# Planning Statement - Section 146B Alteration Request (ABP PA92.319013)

**Alterations to the permitted design of the replacement of  
renewable energy plant**

## **Medite DAC Europe**

12 August 2025

DEVELOPMENT AREA 2

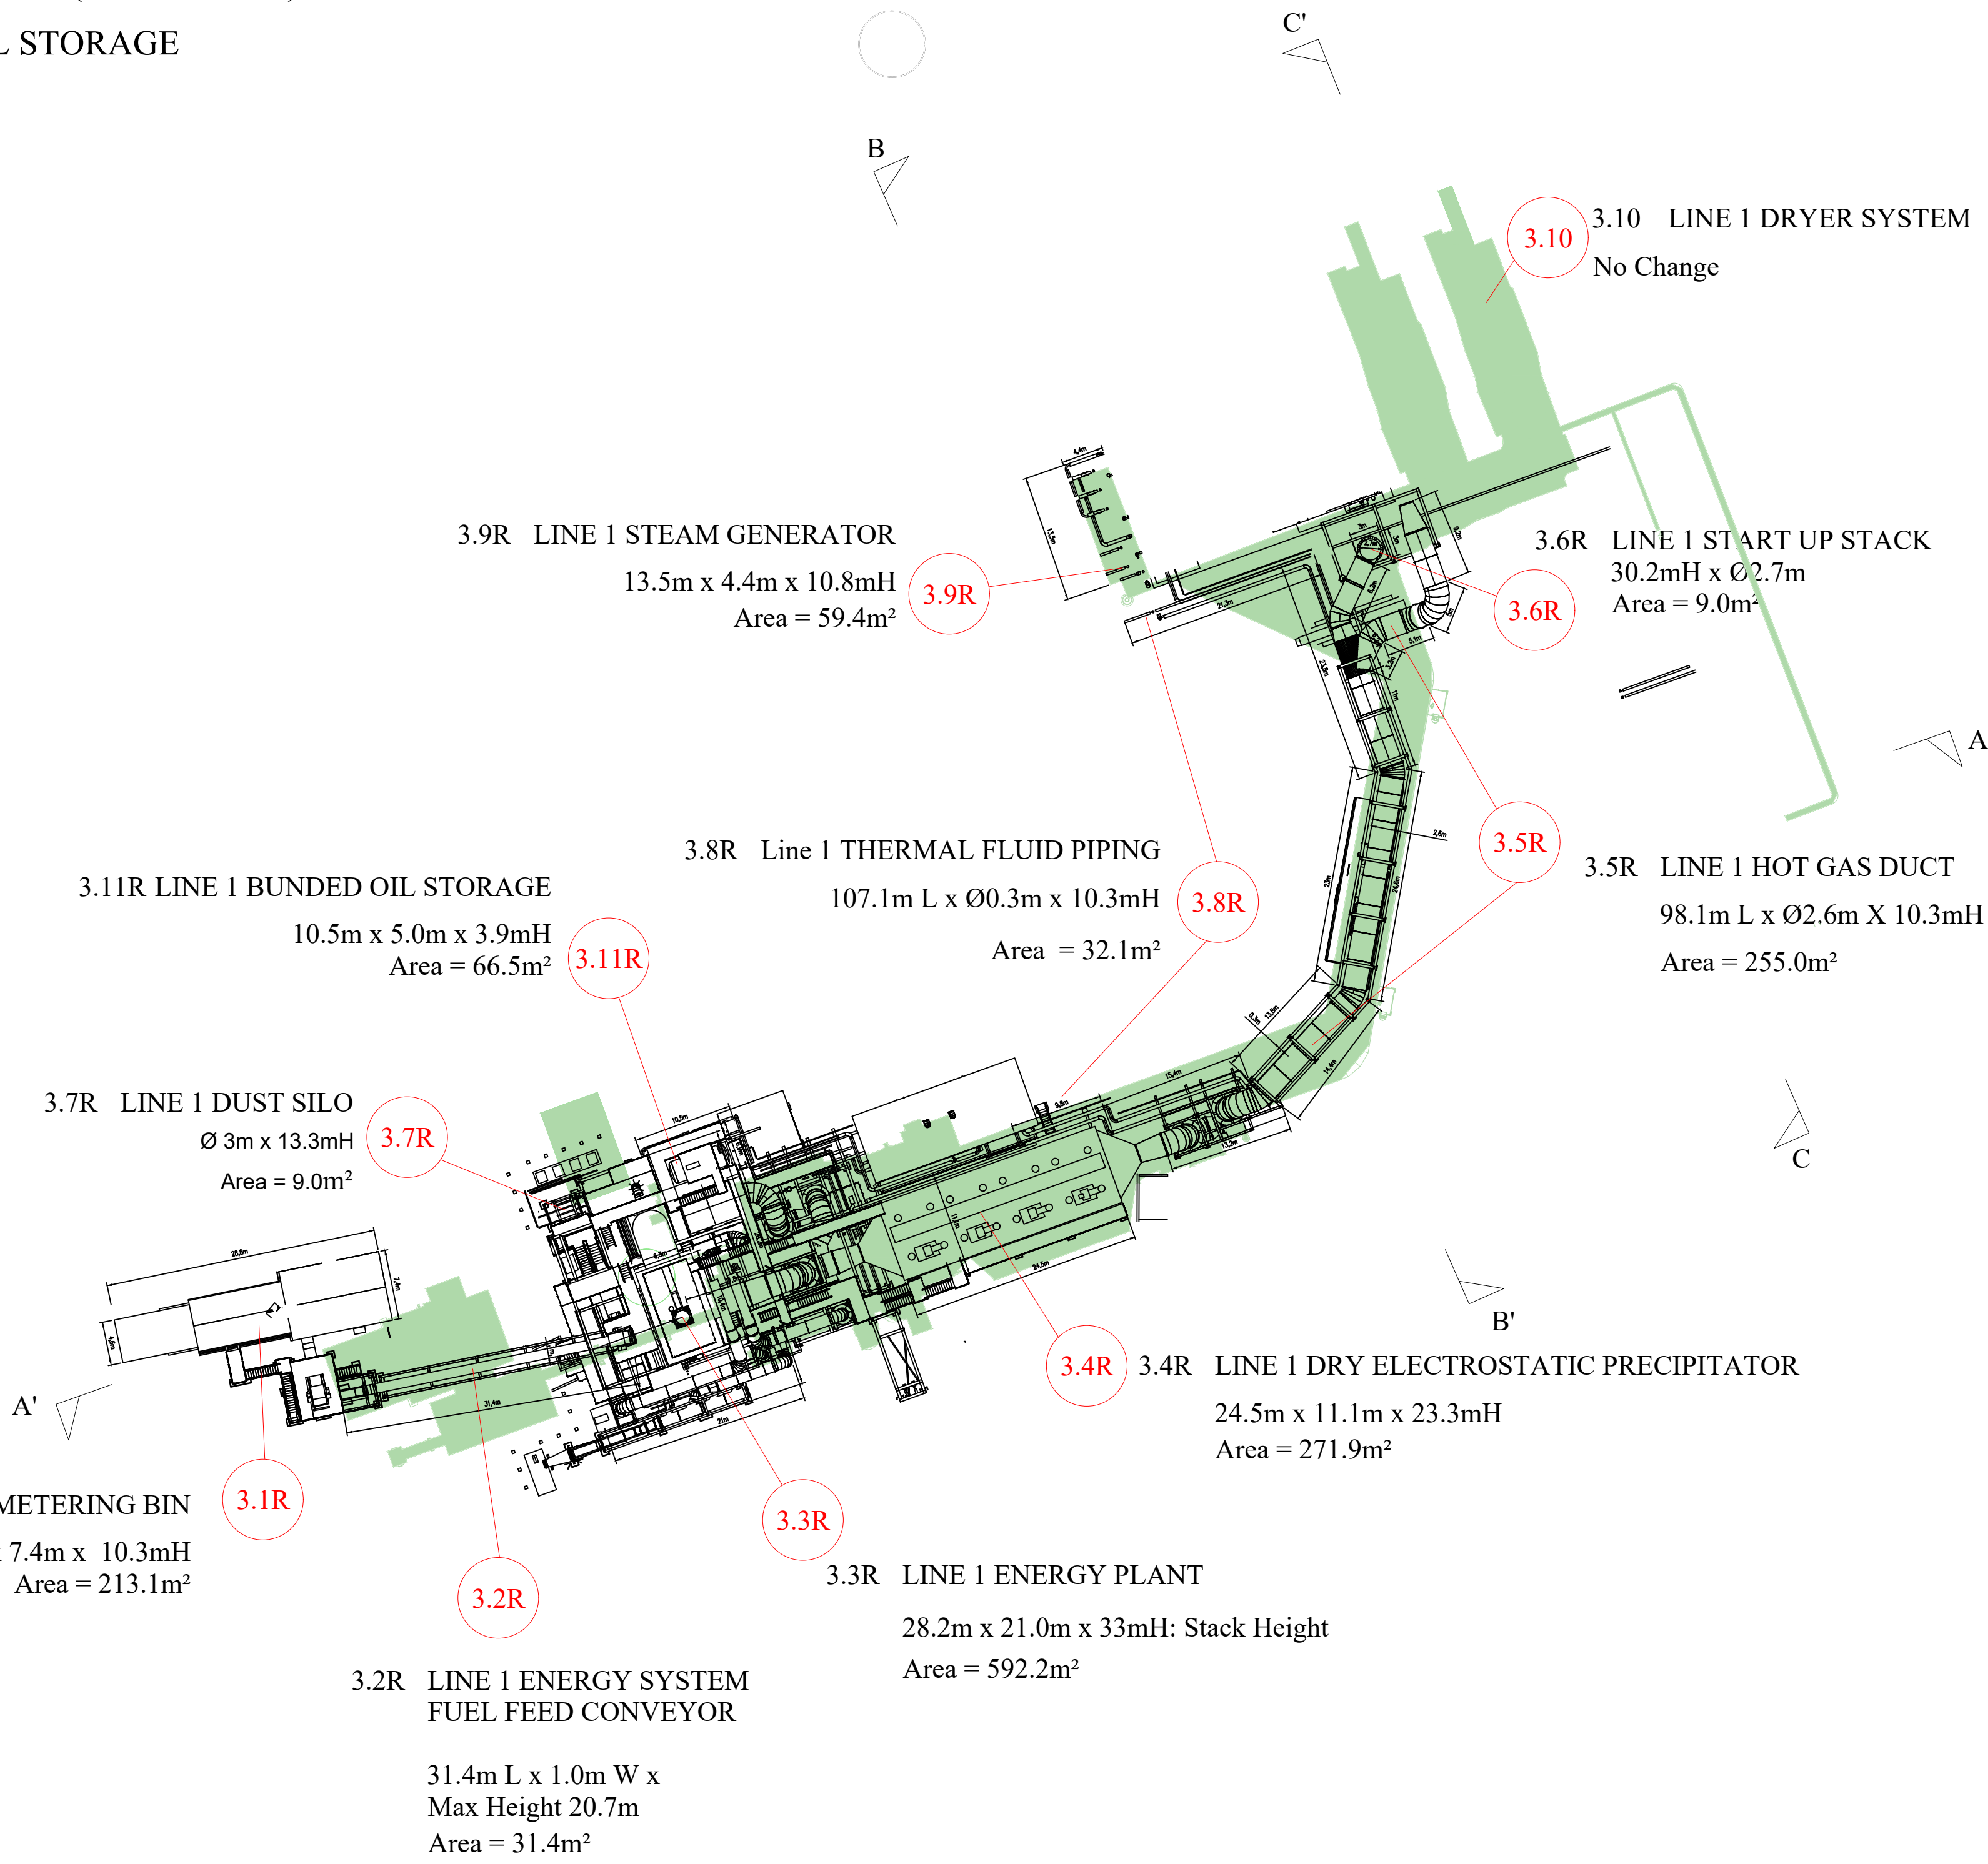
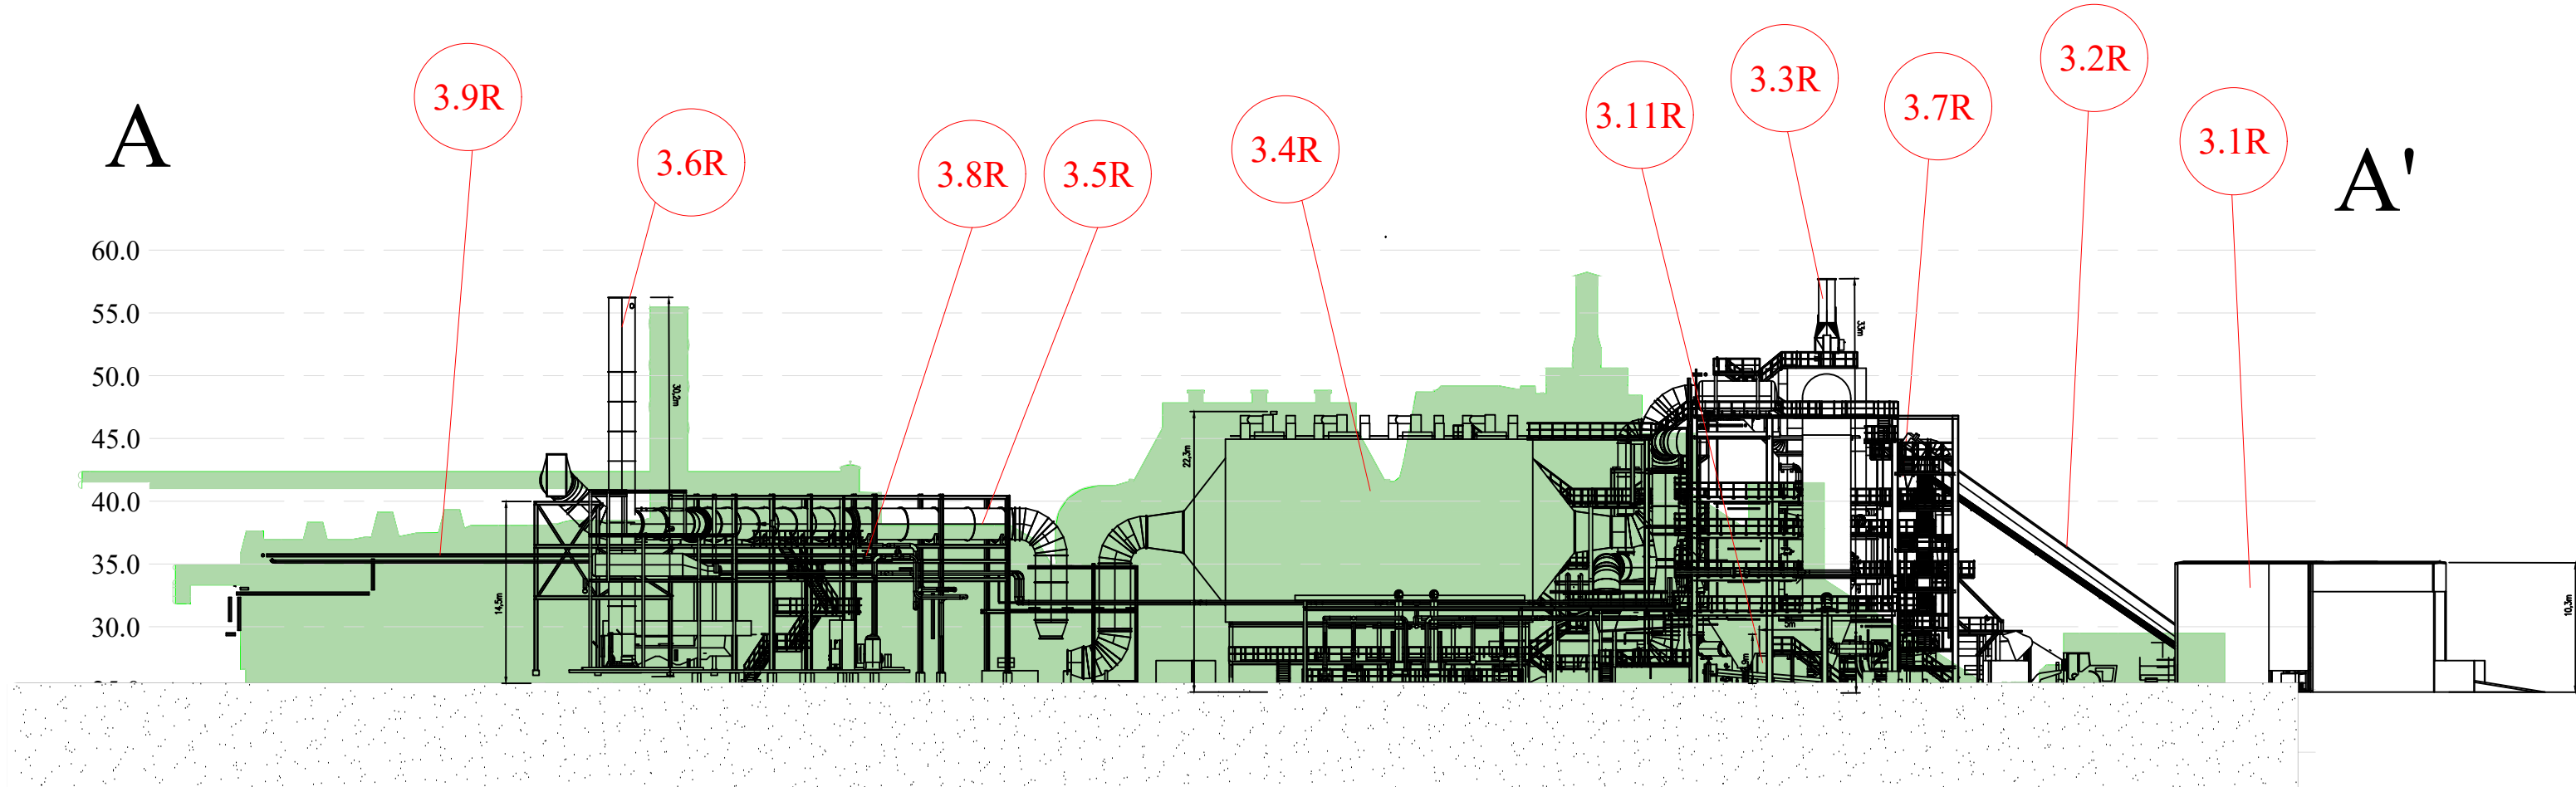
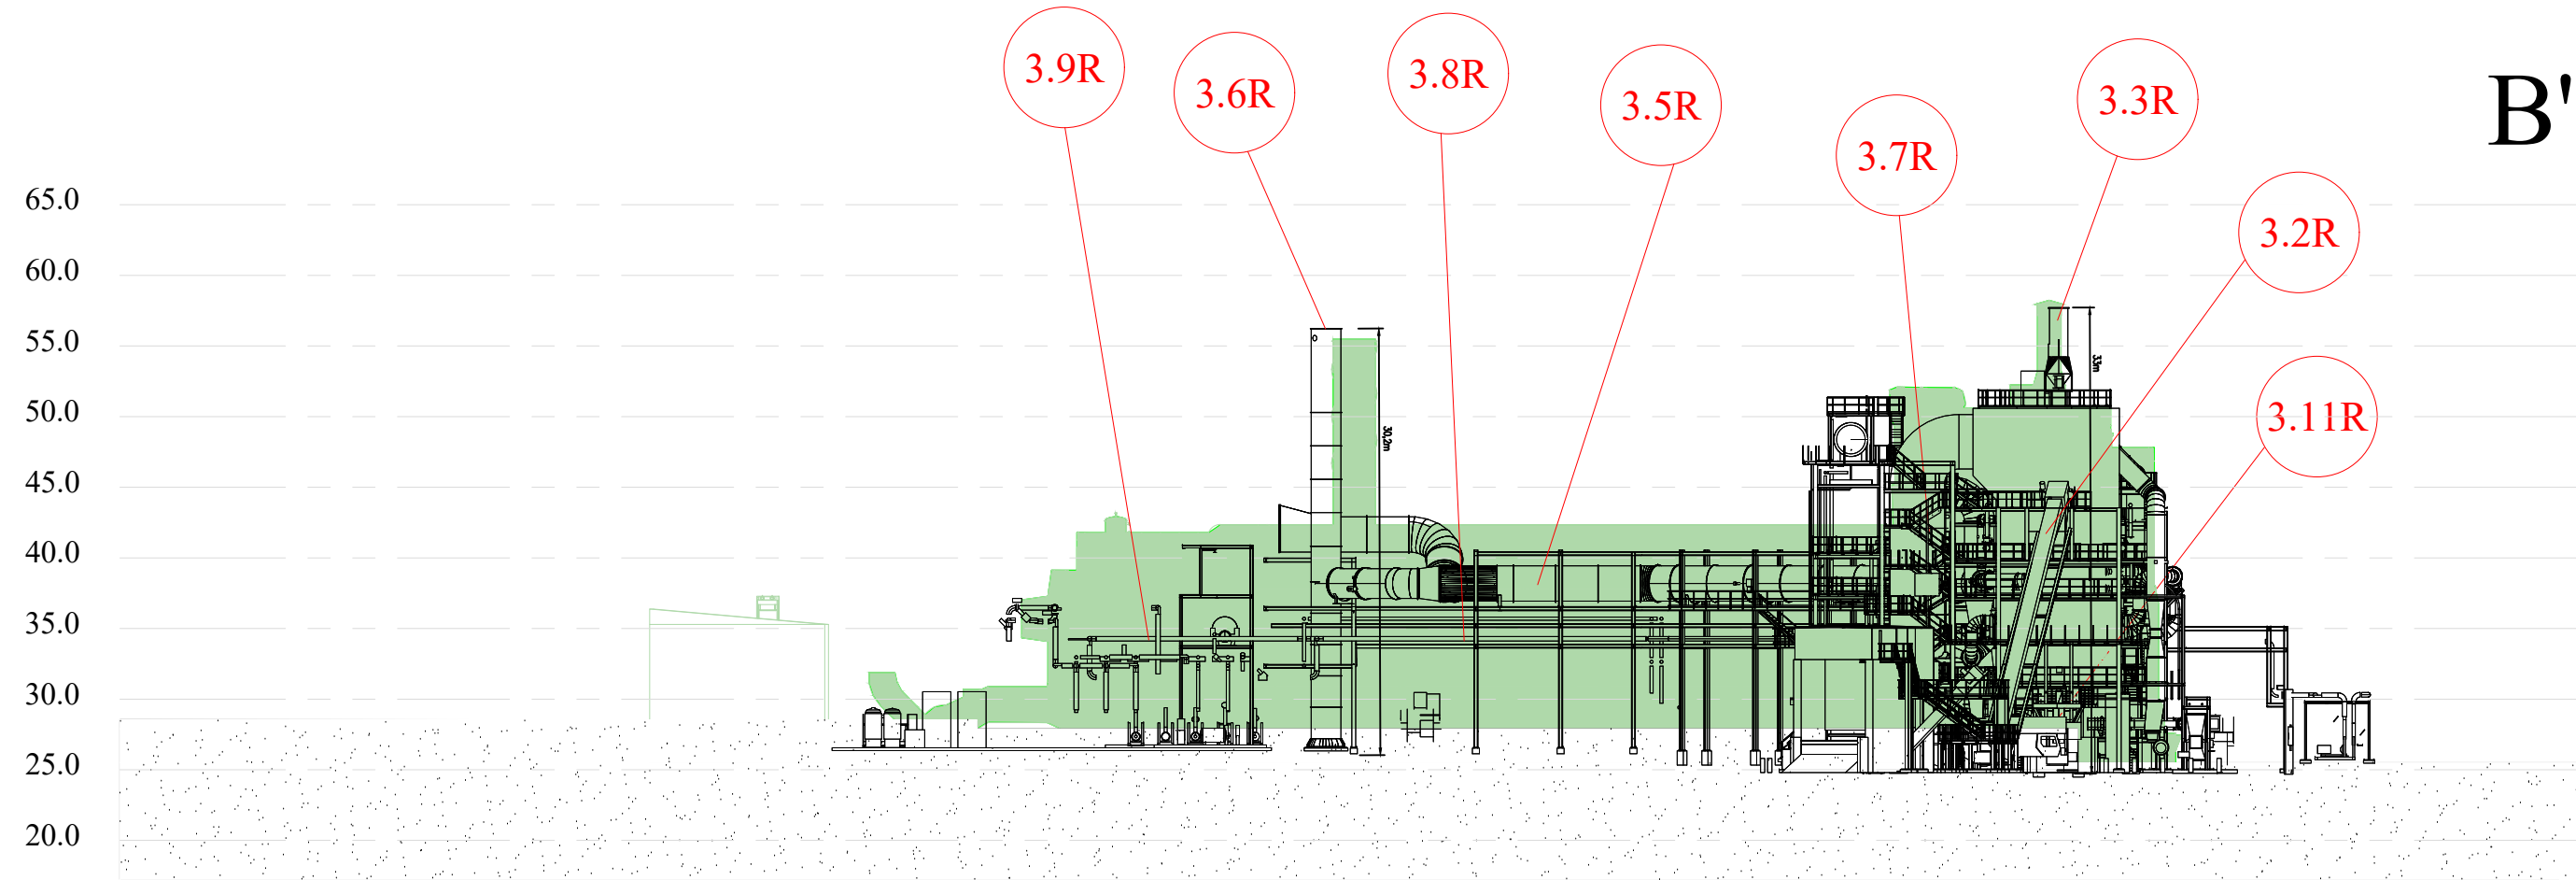
No.	Permitted Item	Description	No. (R)	Proposed Alteration Dimensions	Summary of Alterations
ITEM 3.1	Line 1 Wet Fuel Metering Bin (18.6m x 15.7m x 4.5mH) Area = 254.5 <sup>5</sup> 292.0m <sup>2</sup>	The wet fuel (bark or chips) is received by the Wet Fuel Metering Bin from the conveying systems referred to in Development Area 1.	ITEM 3.1R	Line 1 Wet Fuel Metering Bin 28.8m 7.4m x 10.3mH  Difference in dimensions: +10.2m x -8.3m x +5.8m H	<b>Proposed Area:</b> 213.1m <sup>2</sup>  <b>Area difference:</b> a reduction of -78.9m <sup>2</sup>  Resized & relocated to match operational requirements.  <b>Height increase:</b> +5.8m giving a total height of 10.3m.

ITEM 3.2	Line 1 Energy System Fuel Feed Conveyor (33.2m L x 1.1m W conveyor Max Height 17.8m) Area = 38.0m <sup>2</sup>	The Wet Fuel will be discharged from the Wet Fuel Metering Bin to a Line 1 Wet Fuel Metering Bin Outfeed Weight Belt and a Line 1 Energy System Fuel Feed Conveyor to the Grate Furnace Combustion Chamber with the energy plant.	ITEM 3.2R	Line 1 Energy System Fuel Feed Conveyor 31.4m L x 1.0m W conveyor Max Height 20.7m  Difference in dimensions: -1.8m L x -0.1m x +2.9m H	<b>Proposed Area:</b> 31.4m <sup>2</sup>  <b>Area difference:</b> a slight reduction of -6.6m <sup>2</sup>  Adjusted to accommodate metering bin and energy plant

ITEM 3.3	Line 1 Energy Plant 32.5m x 21.6m x 33m	The energy plant will consist of a wood biomass fired Thermal Fluid Heater (TFH). Inside the TFH, the Wet Fuel will combust	ITEM 3.3R	Line 1 Energy Plant	<b>Proposed Area:</b> 592.2m <sup>2</sup>

No.	Permitted Item	Description	No. (R)	Proposed Alteration Dimensions	Summary of Alterations
	Area = <del>442m<sup>26</sup></del> 702m <sup>2</sup>	<p>together with fresh air provided by the Primary Fan and Secondary Fan inside the Combustion Chamber to produce hot flue gas.</p> <p>An emergency stack on the TFH with a damper will automatically open upon upset conditions. The hot flue gas will supply heat to a thermal fluid that is piped through the energy plant, which in turn provides heat to the Line 1 press and a Steam Generator).</p> <p>There are no changes associated with the regulated release points (Core Dryer A2-5 and Face Dryer A2-6).</p>		<p>28.2m x 21.0m x 33mH: Stack Height</p> <p><b>Difference in dimensions:</b> -4.3m x -0.6m x 0mH</p>	<p><b>Area difference:</b> a reduction of -109.8m<sup>2</sup></p> <p>Reduced size &amp; minor re-location. Moved by 11.8m west to accommodate equipment. This is not a continuous emission point.</p>

ITEM 3.4	<p>Line 1 Dry Electrostatic Precipitator (within the TFH dims of 27.6m x 13.7m x 23.3mH ) Area = 286.9 m<sup>2</sup></p>	The Fly Ash inside the Hot Gas will be cleaned and captured by a Dry Electrostatic Precipitator (Dry ESP) and discharged through the SSC Rotary Airlock onto the Wet Ash Conveyor. The Bottom Ash will be discharged through the holes on the grate and recovered by the Wet Ash Conveyor to the Ash Storage Bunker for disposal.	ITEM 3.4R	<p>Line 1 Dry Electrostatic Precipitator (within the TFH dims of 24.5m x 11.1m x 23.3.0mH</p> <p><b>Difference in dimensions:</b> -3.1m x -2.6m x 0mH</p>	<p><b>Proposed Area:</b> 271.9m<sup>2</sup> <b>Area difference:</b> a slight reduction of -15.0m<sup>2</sup></p> <p>Resized &amp; Location moved to accommodate equipment</p>

ITEM 3.5	<p>Line 1 Hot Gas Duct 105m long x Ø3.2m Area = 336.0m<sup>2</sup></p>	The Hot Gas will be transported to the Line 1 Dryer Systems (Core and Face dryers) via the Hot Gas Duct where it will be mixed with ambient air for the purpose of drying the wet wood fibre. The existing mixing chambers located within the Line 1 Dryer Building will be modified to accommodate the new hot gas duct.	ITEM 3.5R	<p>Line 1 Hot Gas Duct 98.1m long x Ø2.6m</p> <p><b>Difference in dimensions:</b> -6.9m x Ø-0.6m</p>	<p><b>Proposed Area:</b> 255.0m<sup>2</sup> <b>Area difference:</b> a reduction of -81.0m<sup>2</sup></p>

No.	Permitted Item	Description	No. (R)	Proposed Alteration Dimensions	Summary of Alterations
ITEM 3.6	Line 1 Start Up Stack (30.2mH x Ø3.6m) Area = 10.8m <sup>2</sup>	The Hot Gas duct will contain an abort gate & Start-up Stack. This Abort Gate and start-up stack serves as a by-pass of the Hot Gas Flow to the dryer to atmosphere in case the dryer system is in upset conditions or during plant start-up.	ITEM 3.6R	Line 1 Start Up Stack 30.2mH x Ø2.7m  Difference in dimensions: 0mH x -0.9m	<b>Proposed Area:</b> 9.0m <sup>2</sup>  <b>Area difference:</b> a slight reduction of -1.8m <sup>2</sup>  Moved due to constructability constraints 30.2 m height is maintained and relocated by 10.3m east. This change will not affect the assumptions in the EIAR as it is not a continuous emission point.

ITEM 3.7	Line 1 Sander Dust Silo (Ø 6.0m x 16mH) Area = 28.3m <sup>2</sup>	As referenced in 'Pneumatic (Dry Fuel) Systems' in Development Area 1, the existing extraction systems are to be modified and will a proposed Sander Dust Silo Ø 6.0m x 16mH and associated filter plant, located adjacent to the proposed Line 1 Energy Plant. The Sander Dust Silo will discharge material into the Line 1 Energy Plant as fuel.	ITEM 3.7R	Line 1 Sander Dust Silo (Ø 3.0m x 13.3mH) Difference in dimensions: 0m	<b>Proposed Area:</b> 9.0m <sup>2</sup>  <b>Area difference:</b> reduction of -19.3m <sup>2</sup>  Incorporated into the frame structure of the to the energy plant

ITEM 3.8	Line 1 Thermal Fluid Piping 217m L x Ø 0.6m x 16.3mH Area = <del>40.9</del> 130.2 m <sup>2</sup>	The Thermal Fluid Piping will transport the heated thermal fluid to and from the energy plant and both the existing Line 1 Press and a new steam generator.	ITEM 3.8R	Line 1 Thermal Fluid Piping 107.1m L x Ø 0.3m x 10.3mH Difference in dimensions: -109.9m x Ø-0.3m	<b>Proposed Area:</b> 32.1 m <sup>2</sup>  <b>Area difference:</b> a reduction of -98.1 m <sup>2</sup>

ITEM 3.9	Line 1 Steam Generator 14.4m x 3.5m x 17.9mH Area = 47.5m <sup>2</sup>	The Steam generator will use heated thermal fluid to generate steam for the various existing steam users on Line 1. The new steam piping will connect the steam generator to the existing steam pipe infrastructure.	ITEM 3.9R	Line 1 Steam Generator 13.5m x 4.4m x 10.8mH Difference in dimensions:	<b>Proposed Area:</b> 59.4m <sup>2</sup>  <b>Area difference:</b> an increase of +11.9m <sup>2</sup>

No.	Permitted Item	Description	No. (R)	Proposed Alteration Dimensions	Summary of Alterations
				-0.9m x +0.9m x -7.1mH Reduction of external works as re-located inside existing building.	Reduction in height of pipe work
ITEM 3.10	Line 1 Dryer System 34.0m x 17.5m x 13.9mH Area = 505.7m <sup>2</sup>	The Hot Gas generated by the new Line 1 Energy plant will be utilised in the dryer system to dry wood fibre to produce MDF.	ITEM 3.10	Line 1 Dryer System 34.0m x 17.5m x 13.9mH Area = 505.7m <sup>2</sup> As permitted; Inside existing building	No Area Difference
ITEM 3.11	Line 1 Bunded Oil Storage 10.4m x 6.4m x 3.1mH Area = 66.5m <sup>2</sup>	Bunded Oil Storage Tank	ITEM 3.11R	Line 1 Bunded Oil Storage 10.5m x 6.9m x 3.9mH Difference in dimensions: +0.1m x +0.5m x +0.8mH	<b>Proposed Area:</b> 72.5m <sup>2</sup> <b>Area difference:</b> an increase of +6.0m <sup>2</sup>
